Application no: H08/1313/02

Location: 75 High Street
Gosberton

Amendment: Change from new shop window to brick walls, sash
window & traditional doorway (dwg nos. 02/37/05 & 06)

Additional Comments of Conservation Officer

06A

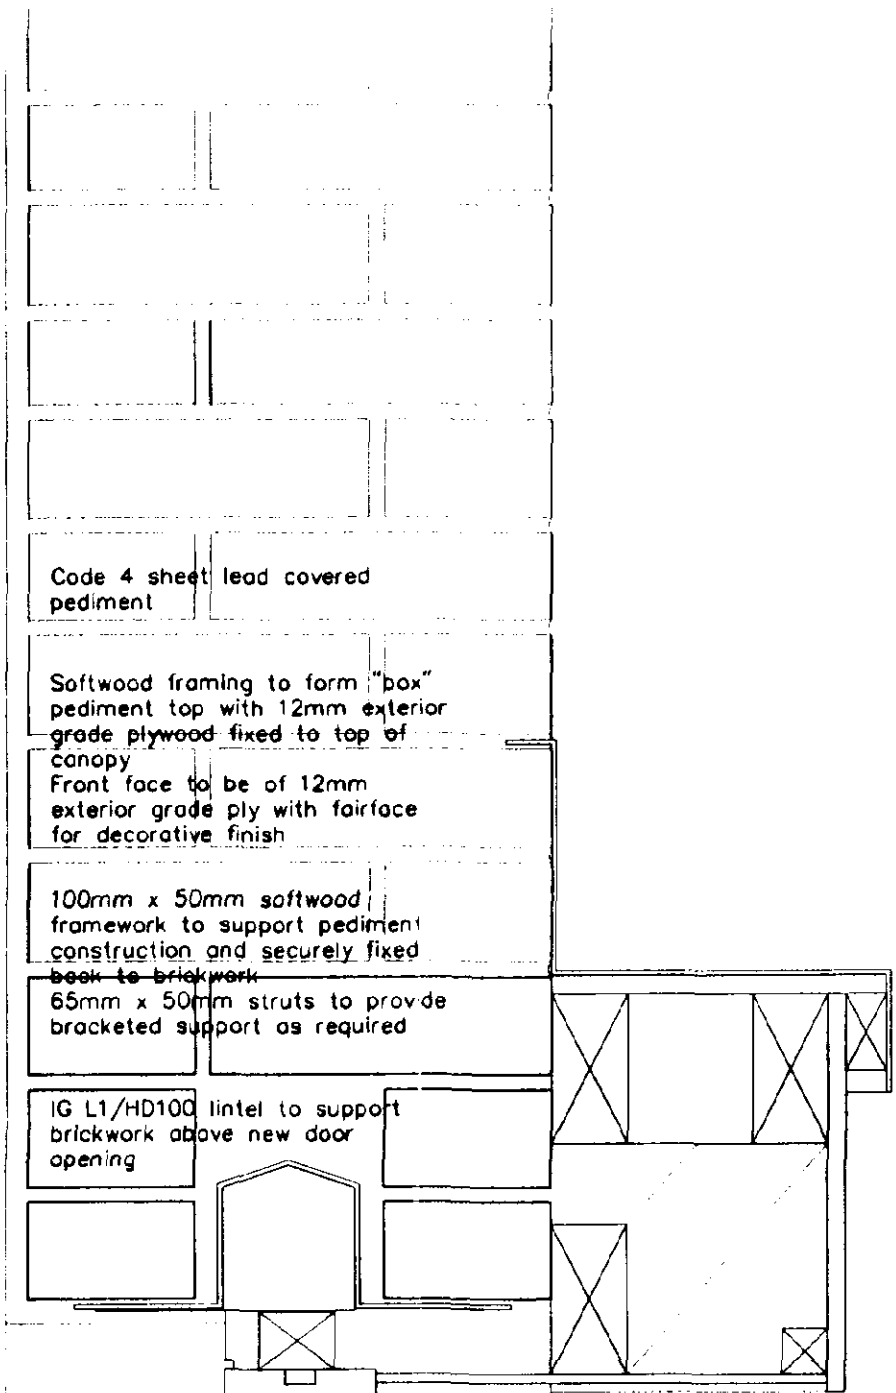
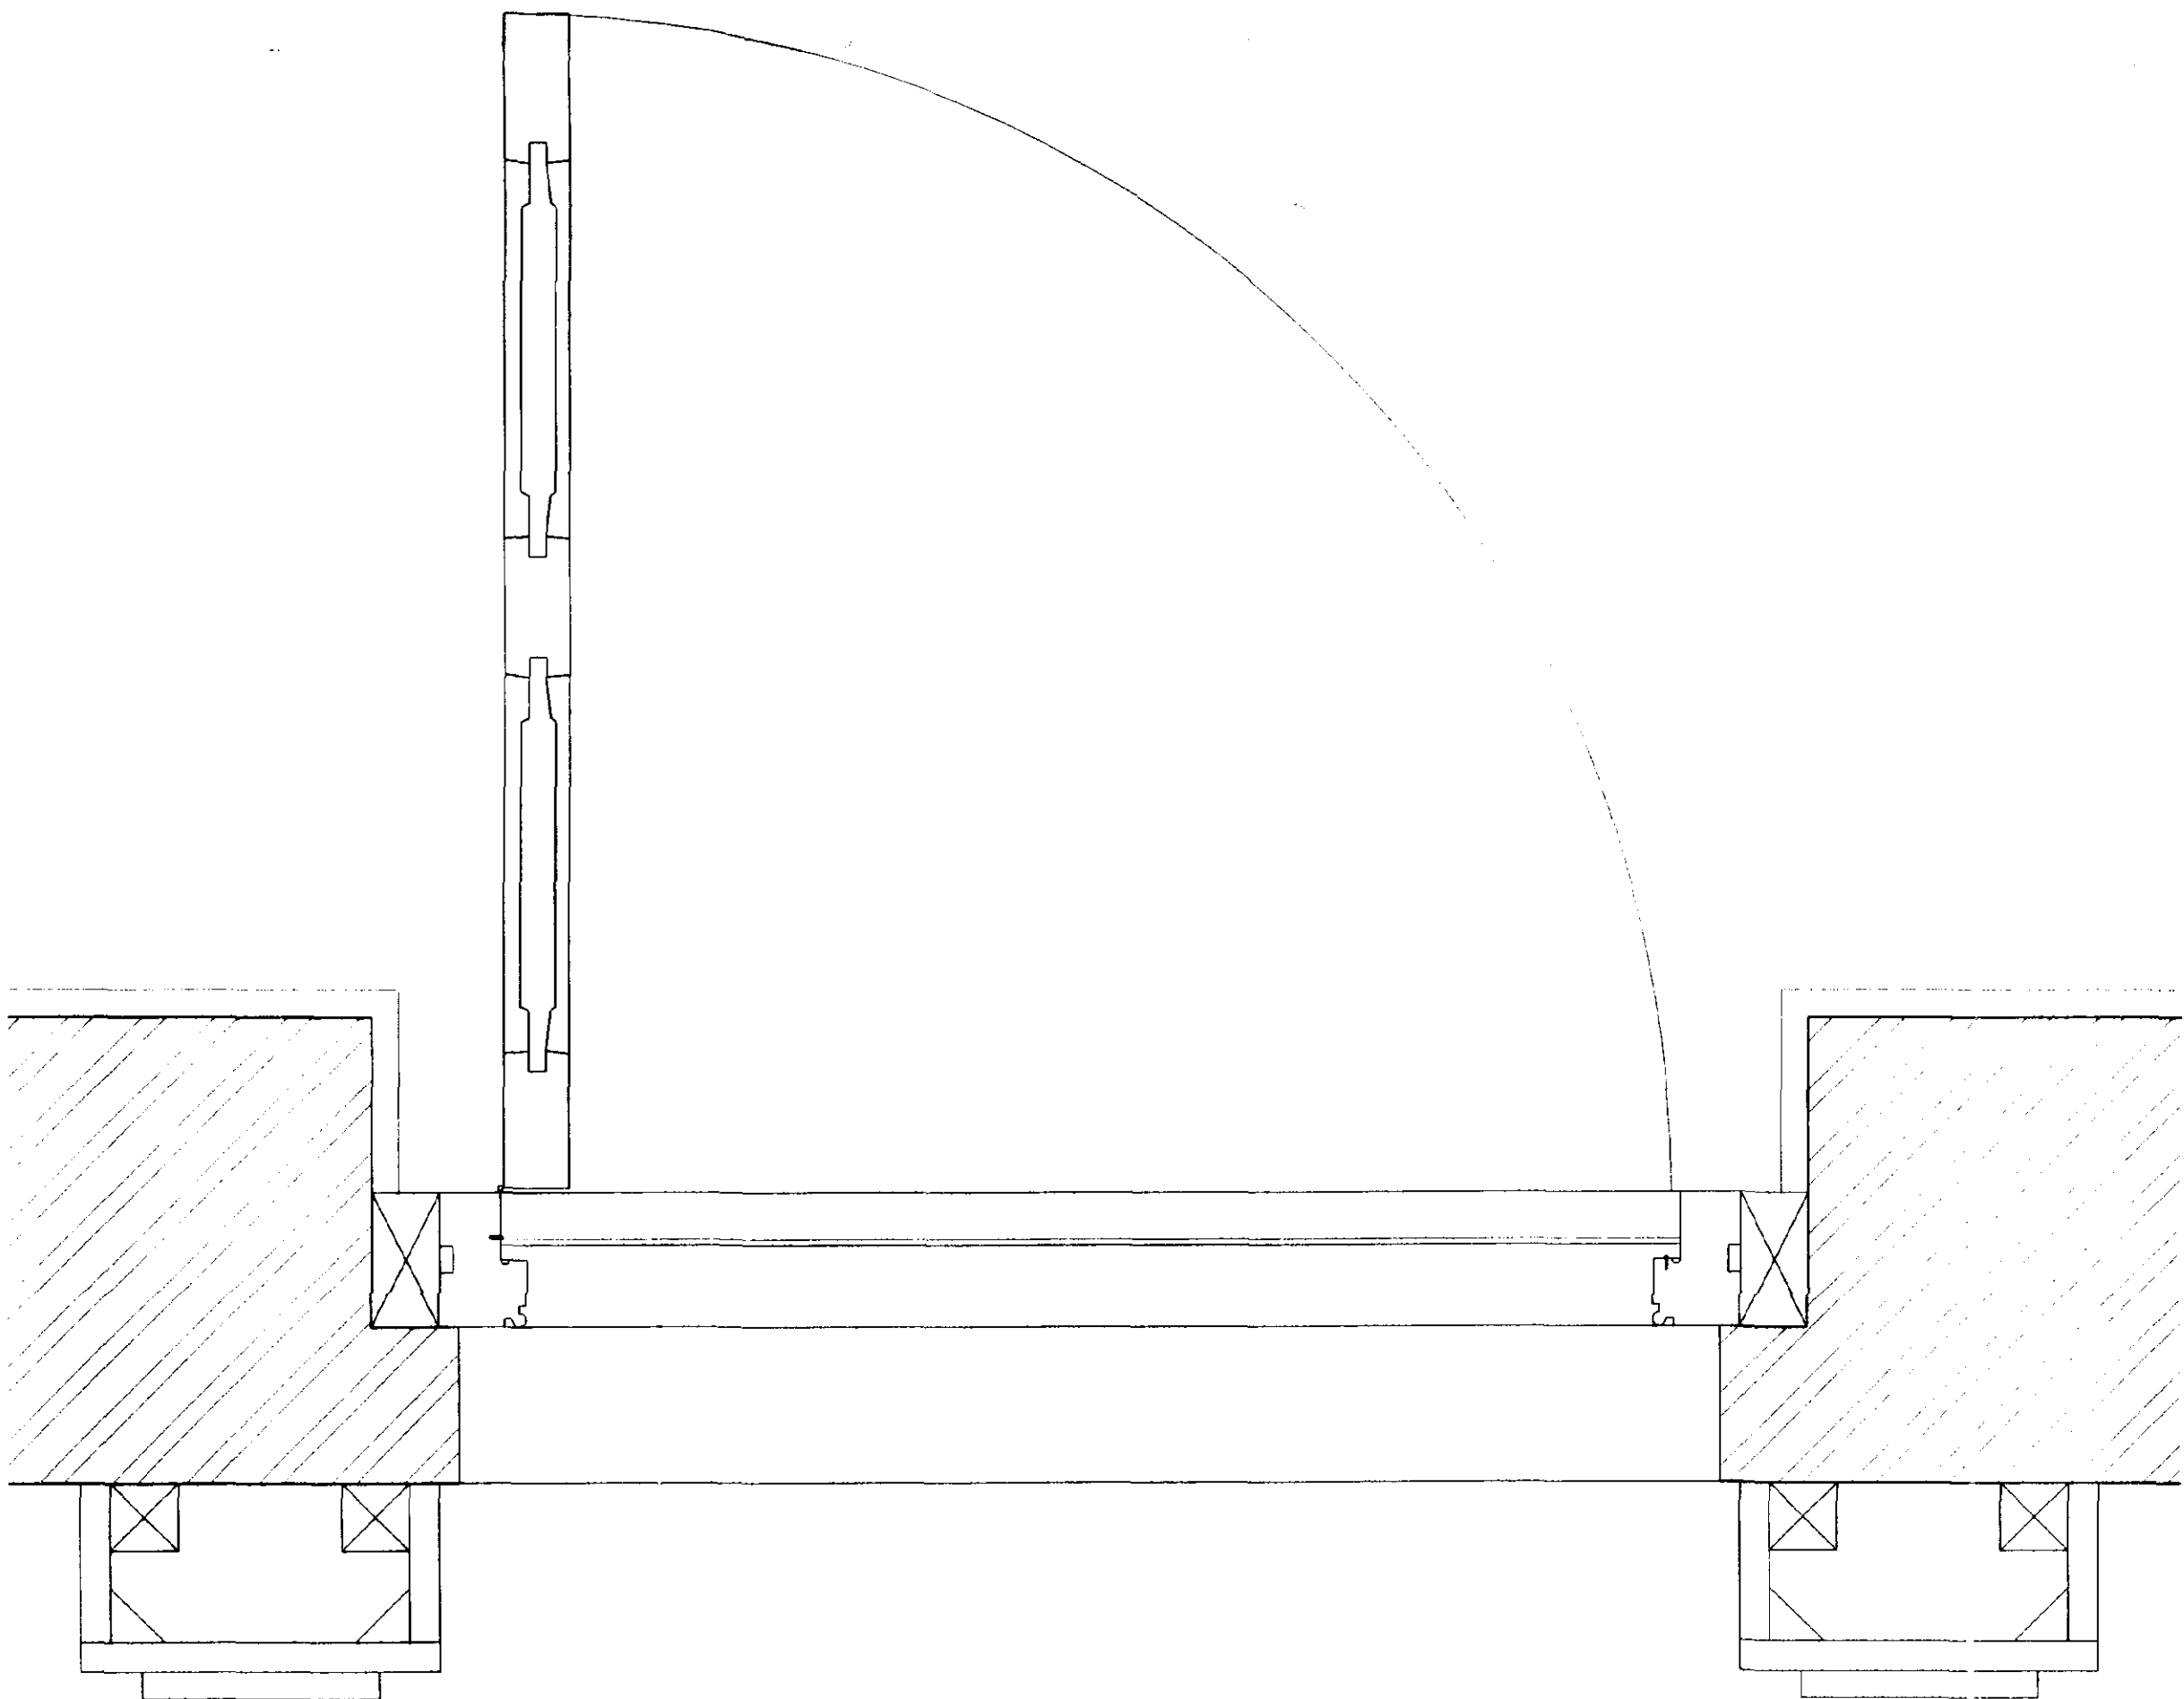
I am happy with the details of the door and window as submitted. I do, however, have some concern over the door surround. The semi circular detail of the pediment is unusual. I have not checked surrounding buildings but none of the listed buildings have this detail. A simple flat entablature would I feel, may be more appropriate. Furthermore, the stark plainness of the pilaster and entablature may well be wrong for the area. I suggest that the applicant be asked to look at the details of nearby door surrounds for a suitable copy to be replicated.

05

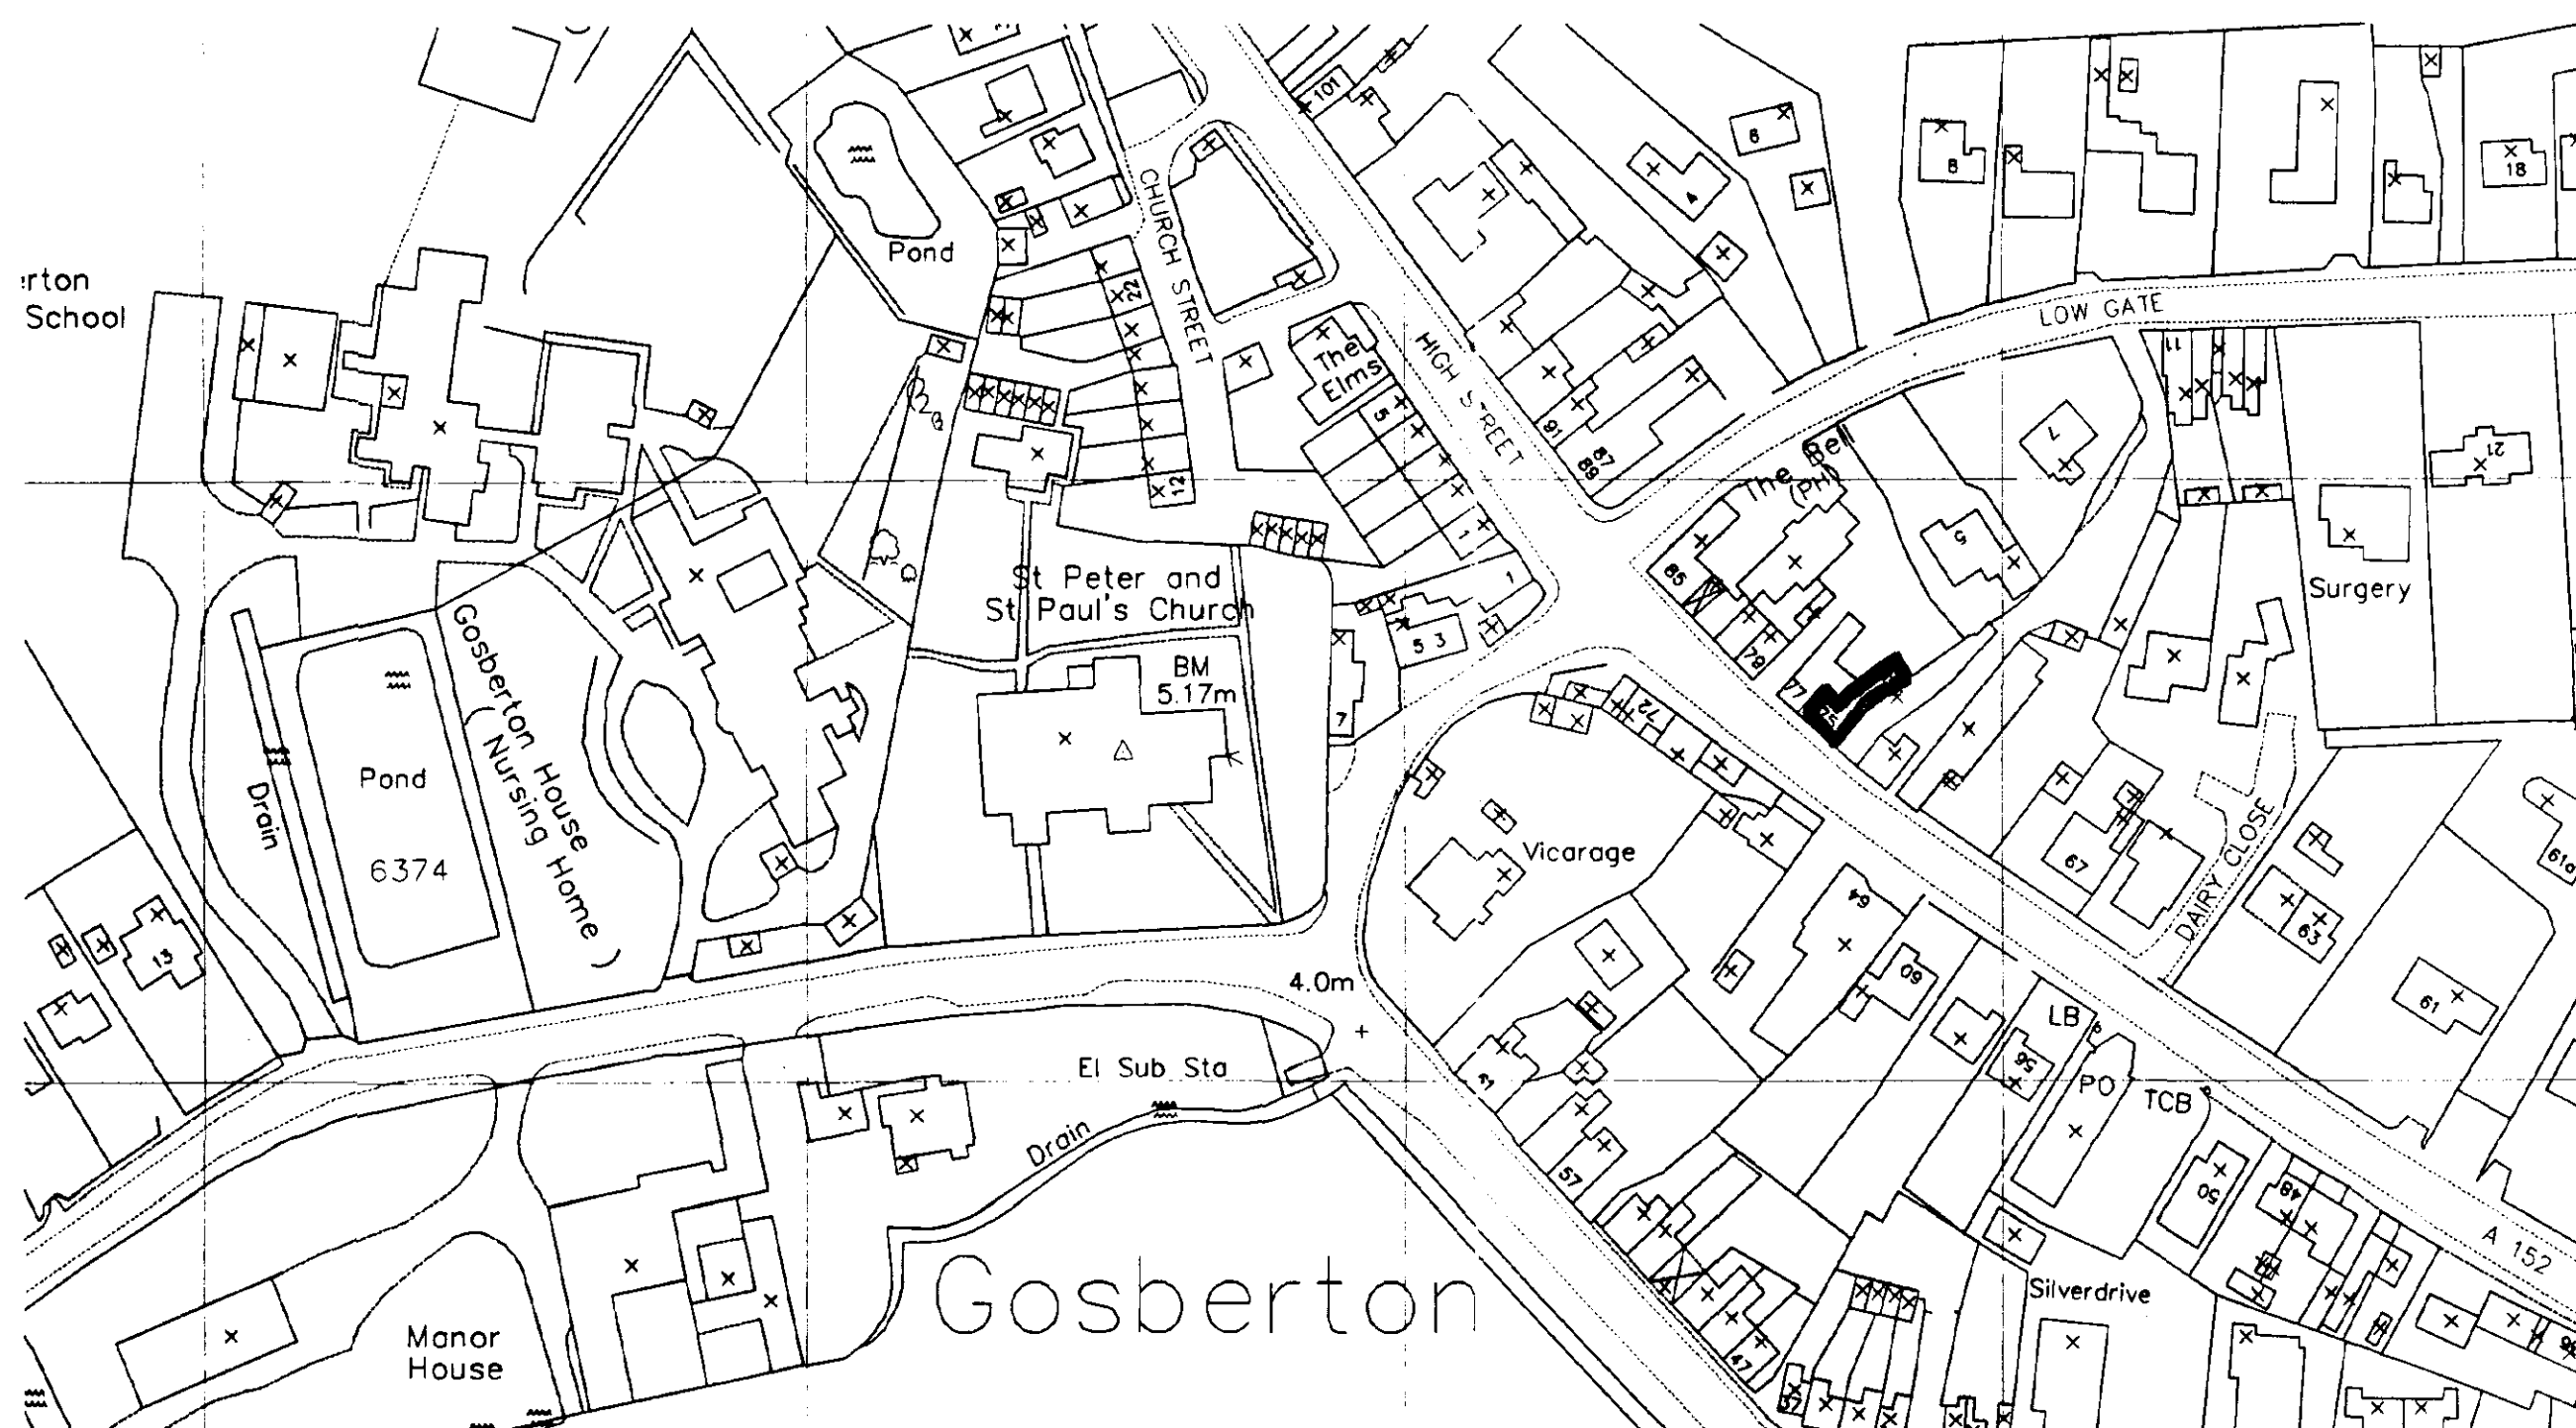
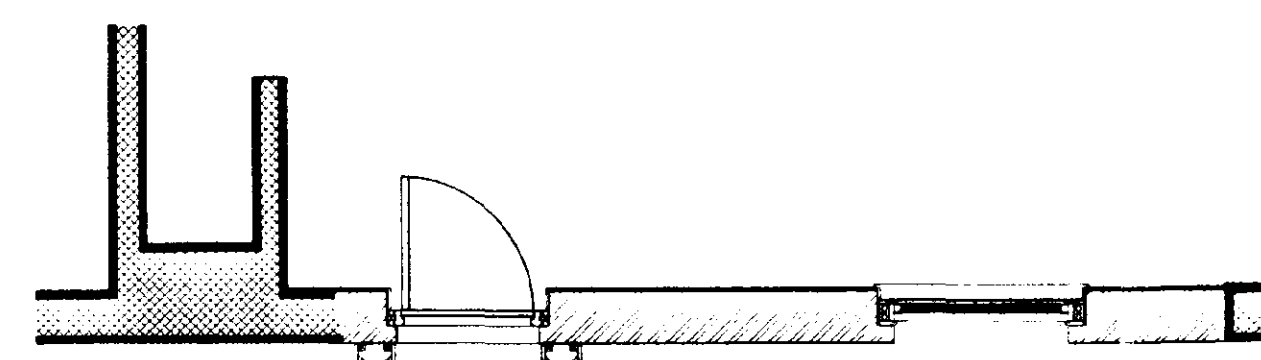
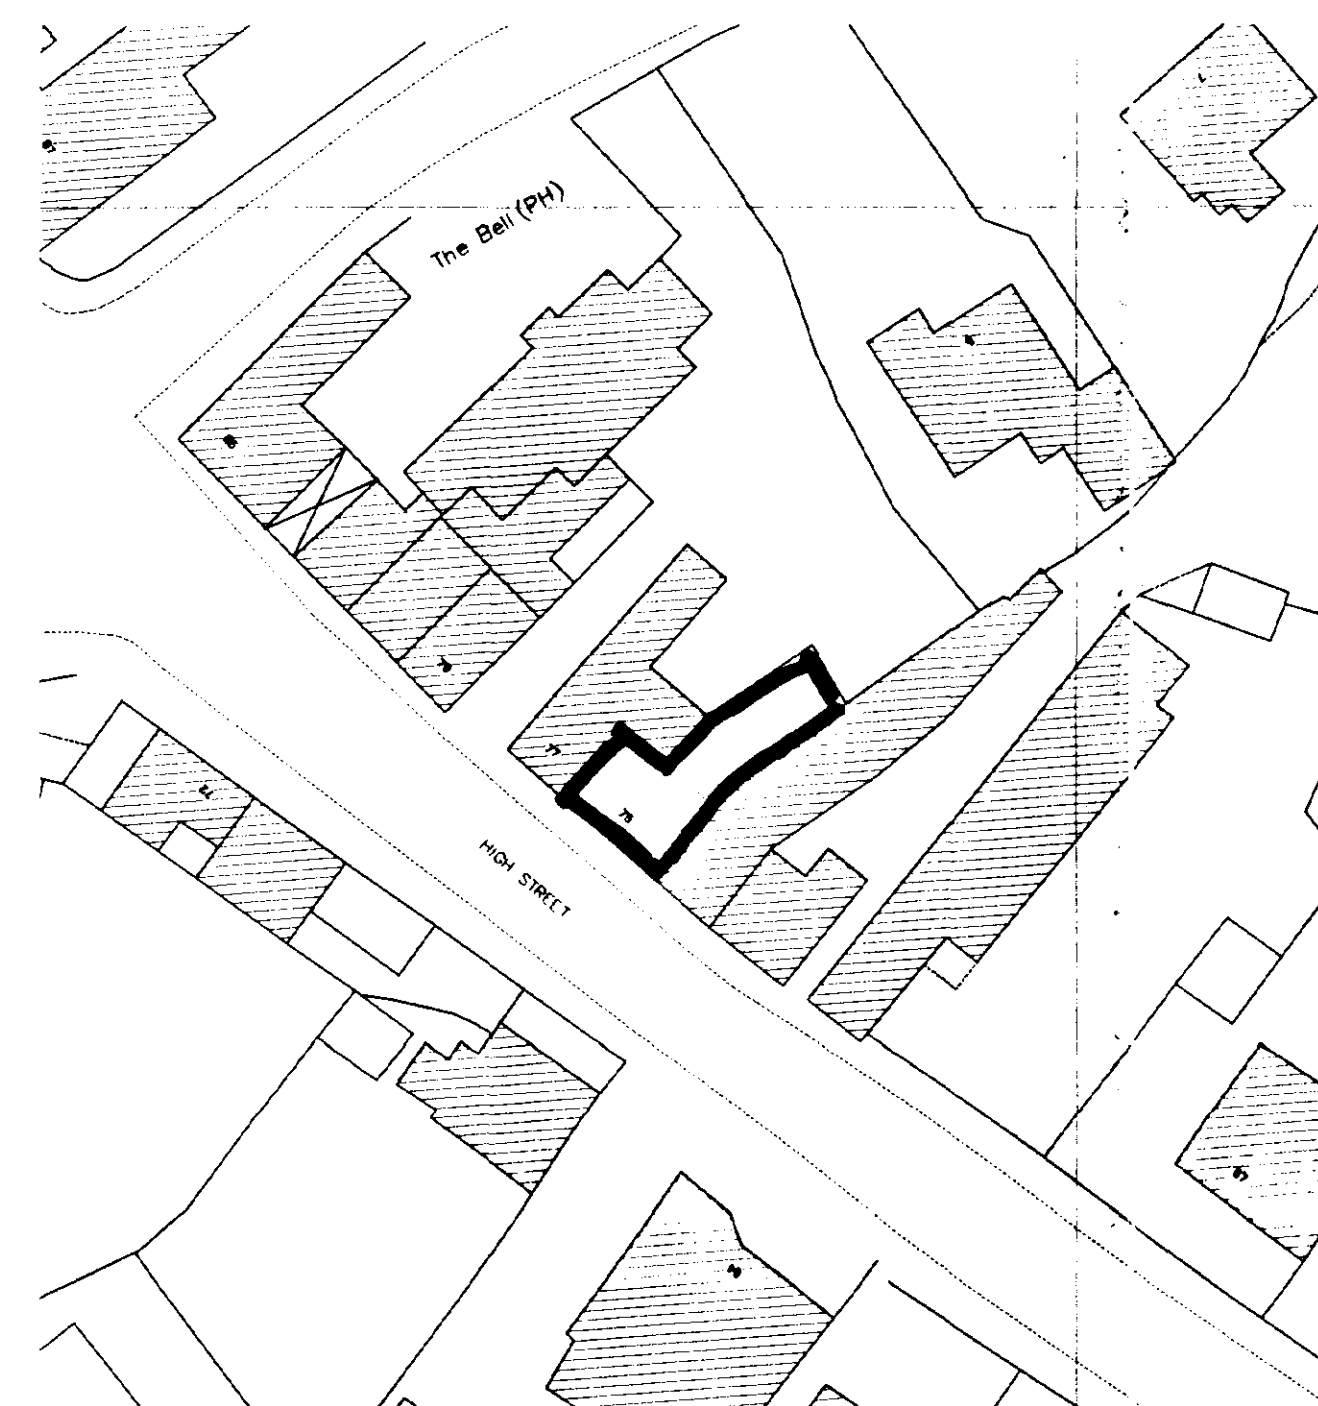
As with all such cases the success will depend on the detailing. Great care must be taken with the brickwork and pointing and I suggest that we reserve the choice of brick to be agreed on site.
